Your Ref: OWPC20163
Our Ref: R/190/18/PL 31-07-2018
Please ask for:
Mrs A Gardner

Demolition of 1 No. existing house & grounds & erection of 2 No. new detached dwellings. This application may affect the character & appearance of the Station Road, East Preston Conservation Area.

St Marys Close Hurst Road Rustington

Thank you for your internet representation made on 10th October 2018 which has been recorded as '**an objection**' with the comments as follows:

Drawing Title:
ADDITIONAL DWELLINGS
BLOCK/ SITE PLAN

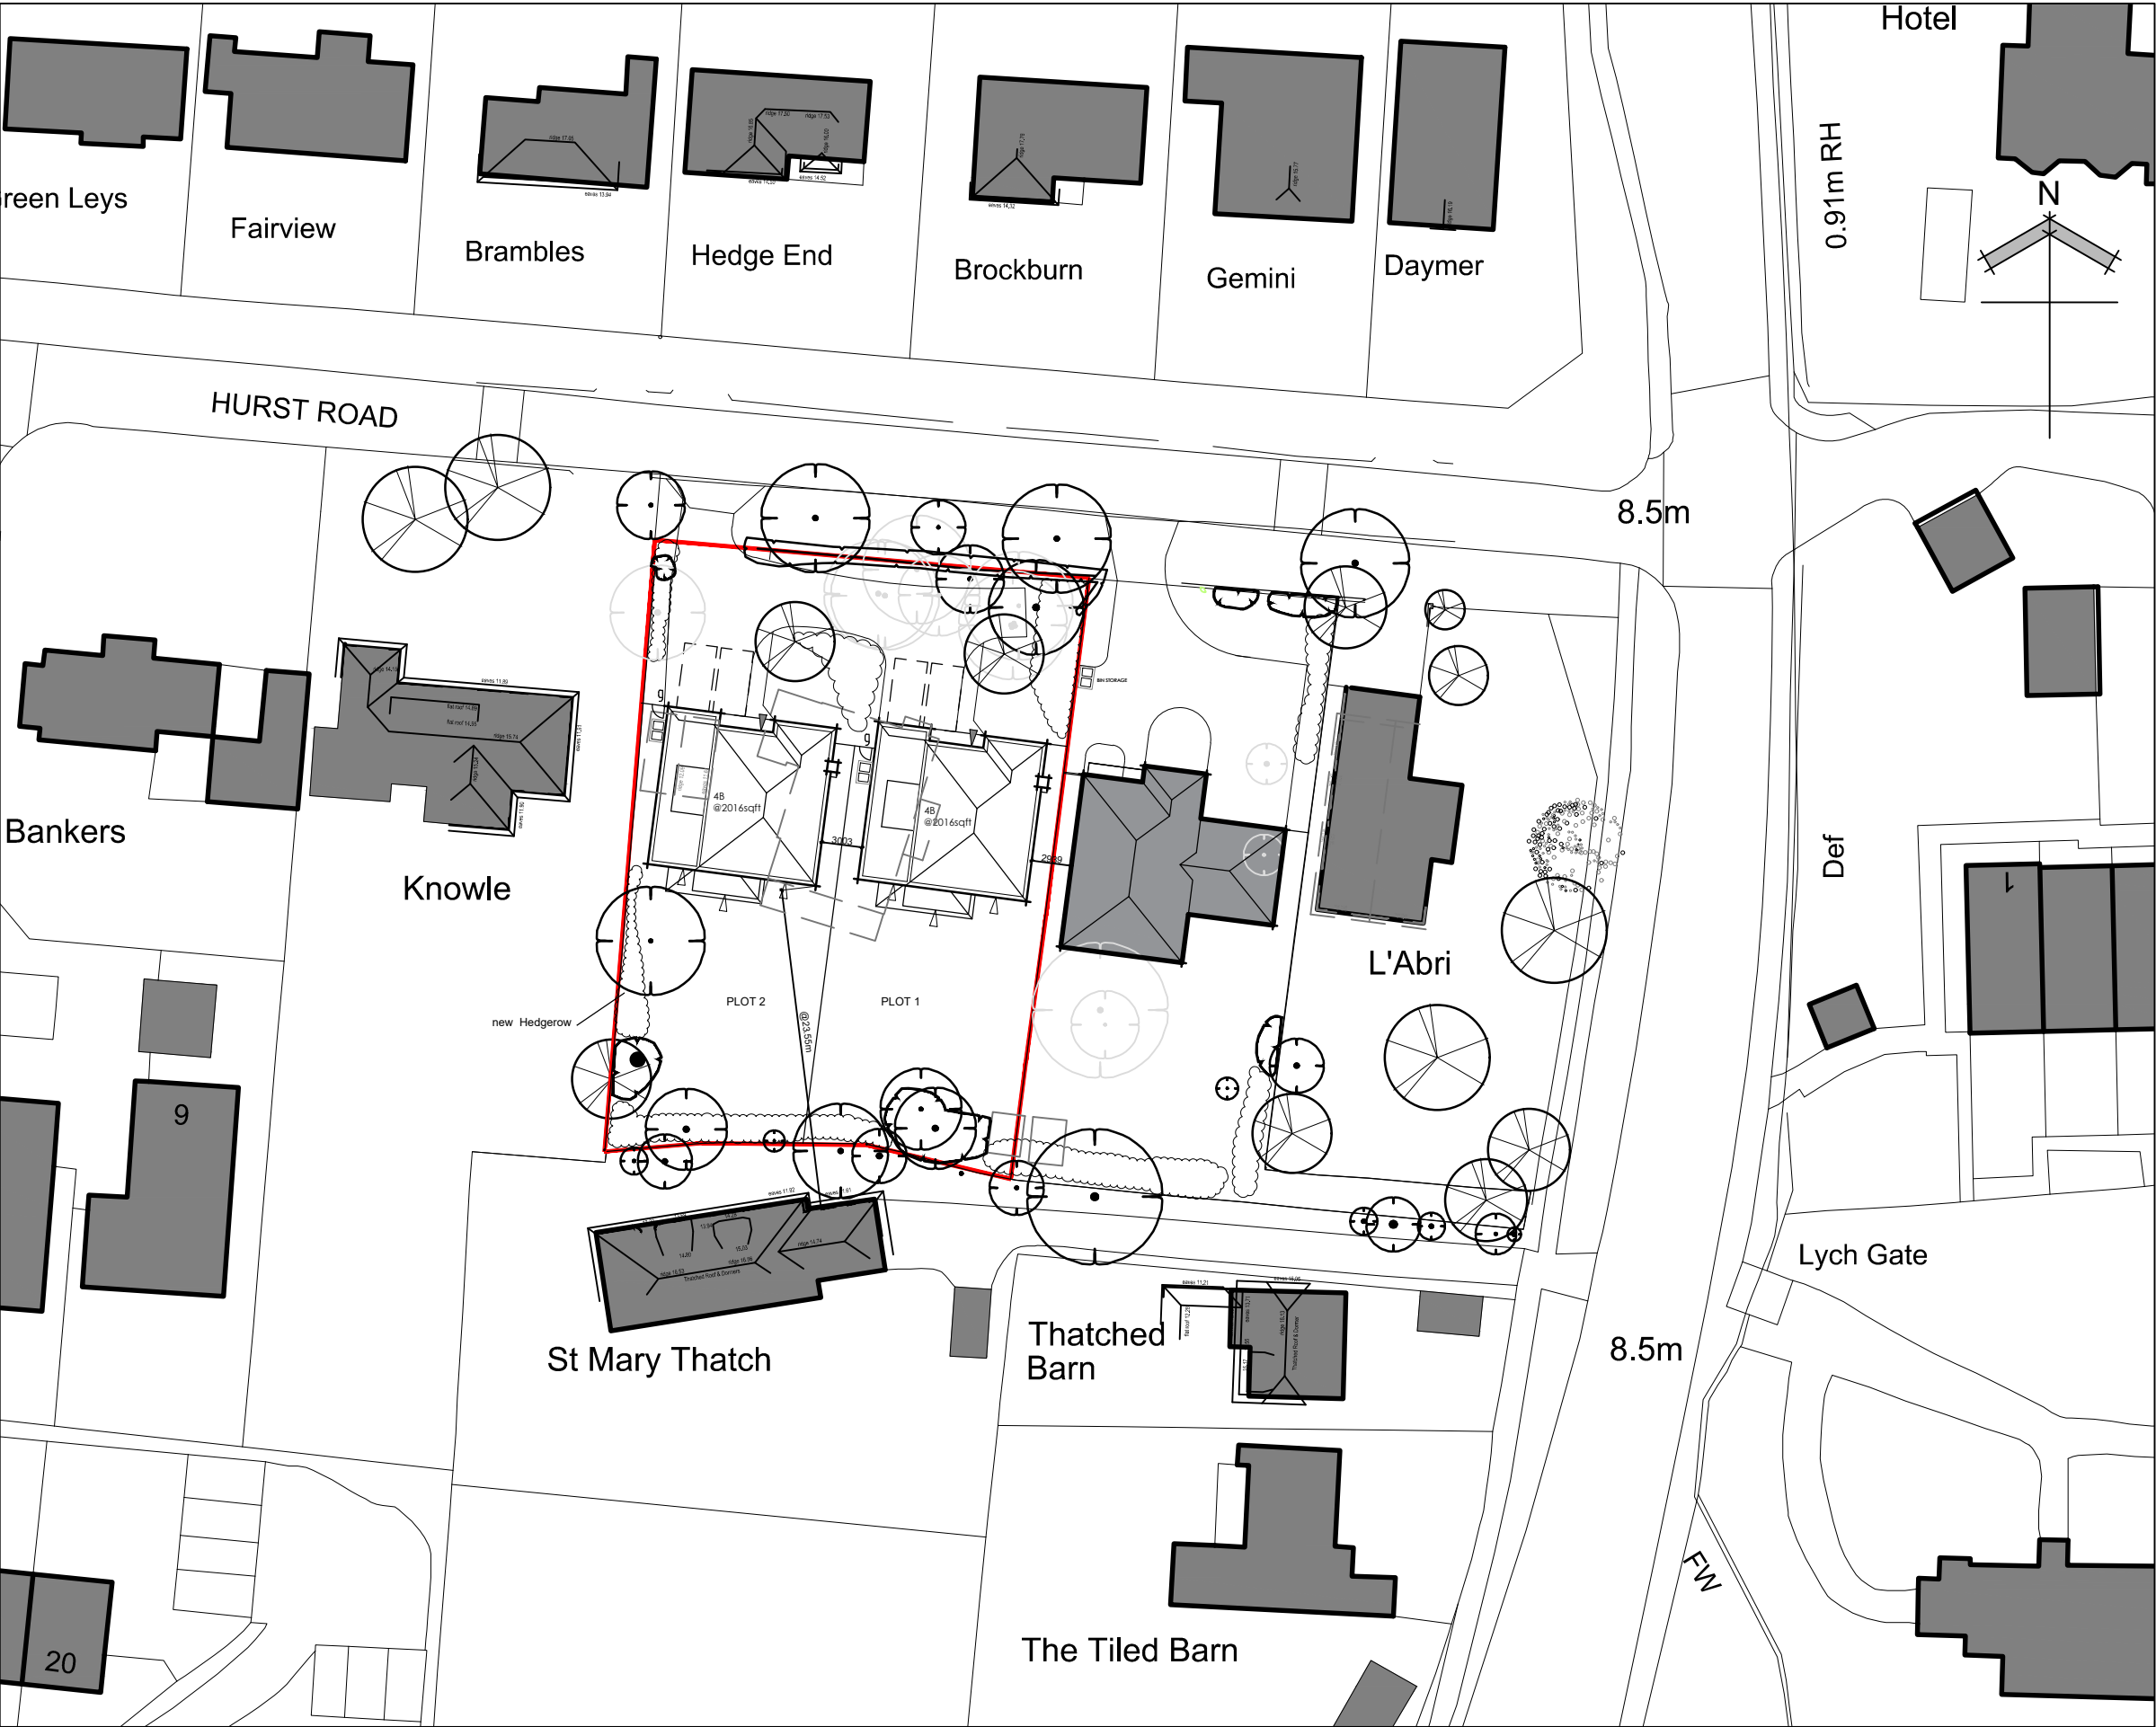
Furthermore, we personally believe that individual driveways would be more desirable for the future owners of the houses and would also reduce parking and manoeuvrability issues in the close. It is imperative that any driveway amendments should not interfere with the trees along the carriageway verge as these are a key characteristic of the road and are the responsibility of the Hurst Road Association.

Drawing Title:
ADDITIONAL DWELLING
PLOTS 1 & 2
ELEVATIONS

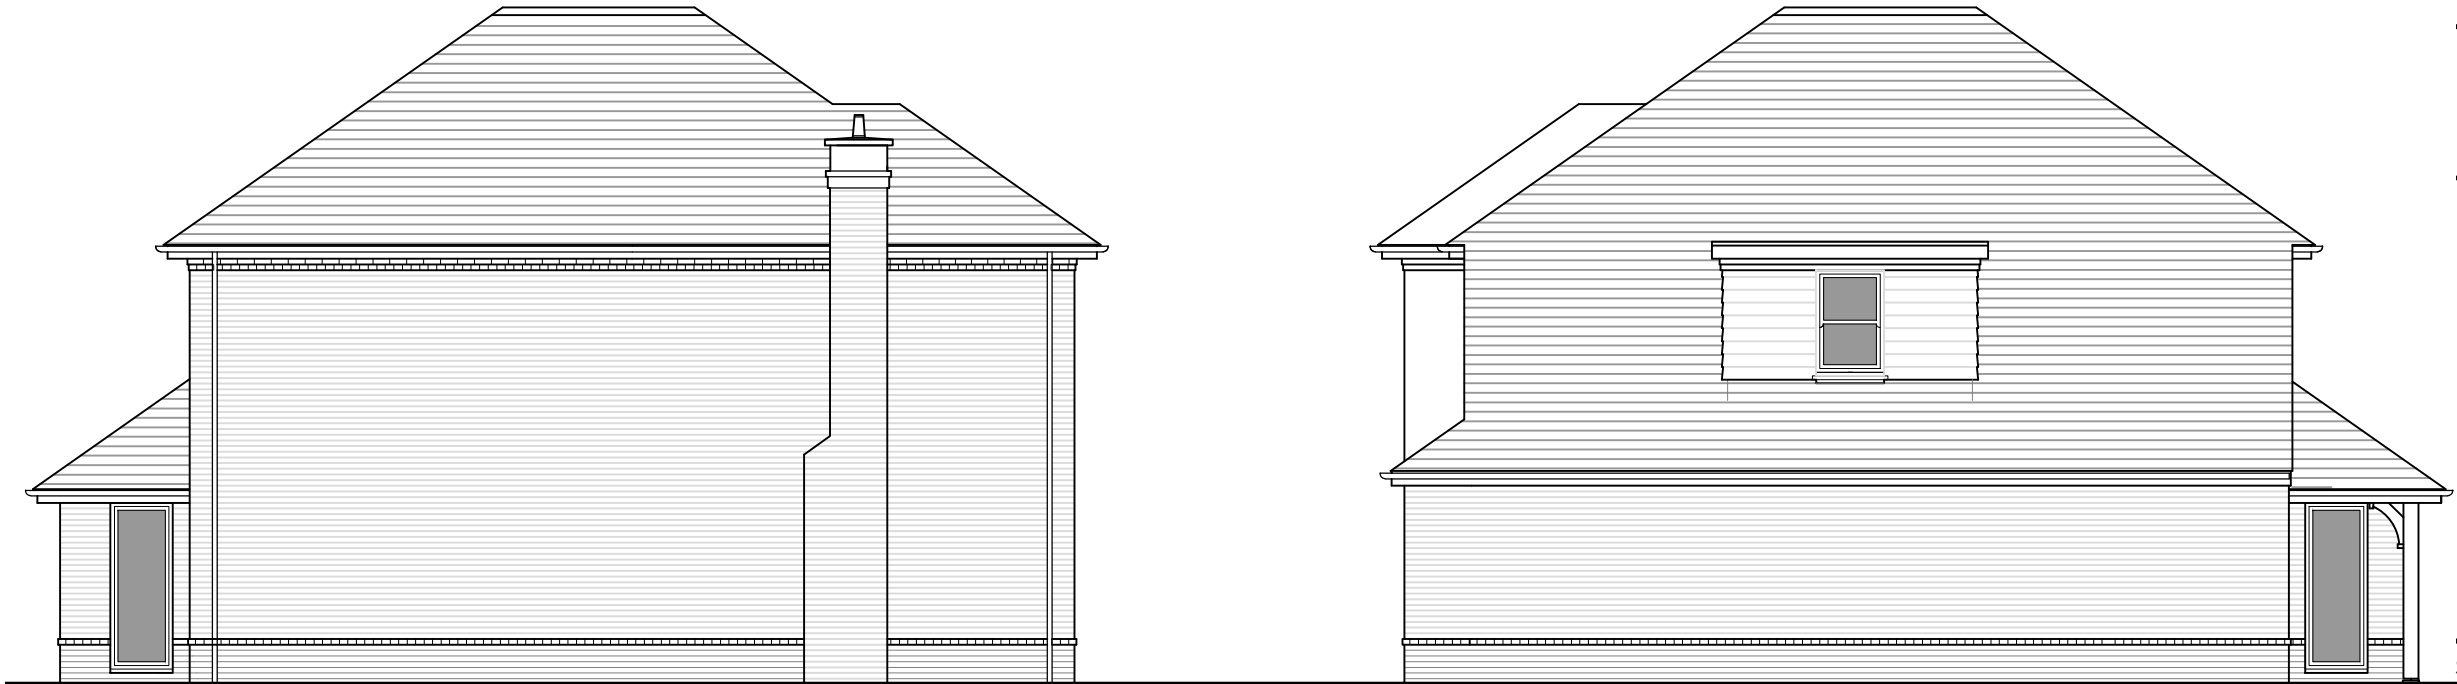
Whilst it is encouraging that the developer has finally reduced the collective number of plots on the site to three (two with this application), it is extremely disappointing and frustrating that they have proposed two identical designs. The individuality of all other properties in Hurst Road gives the road its unique character and the proposed 'cut and paste' houses are clearly not in keeping with this. The developer will no doubt propose different finishes, etc to make them 'unique' but that simply won't hide the fact the elevations are identical.
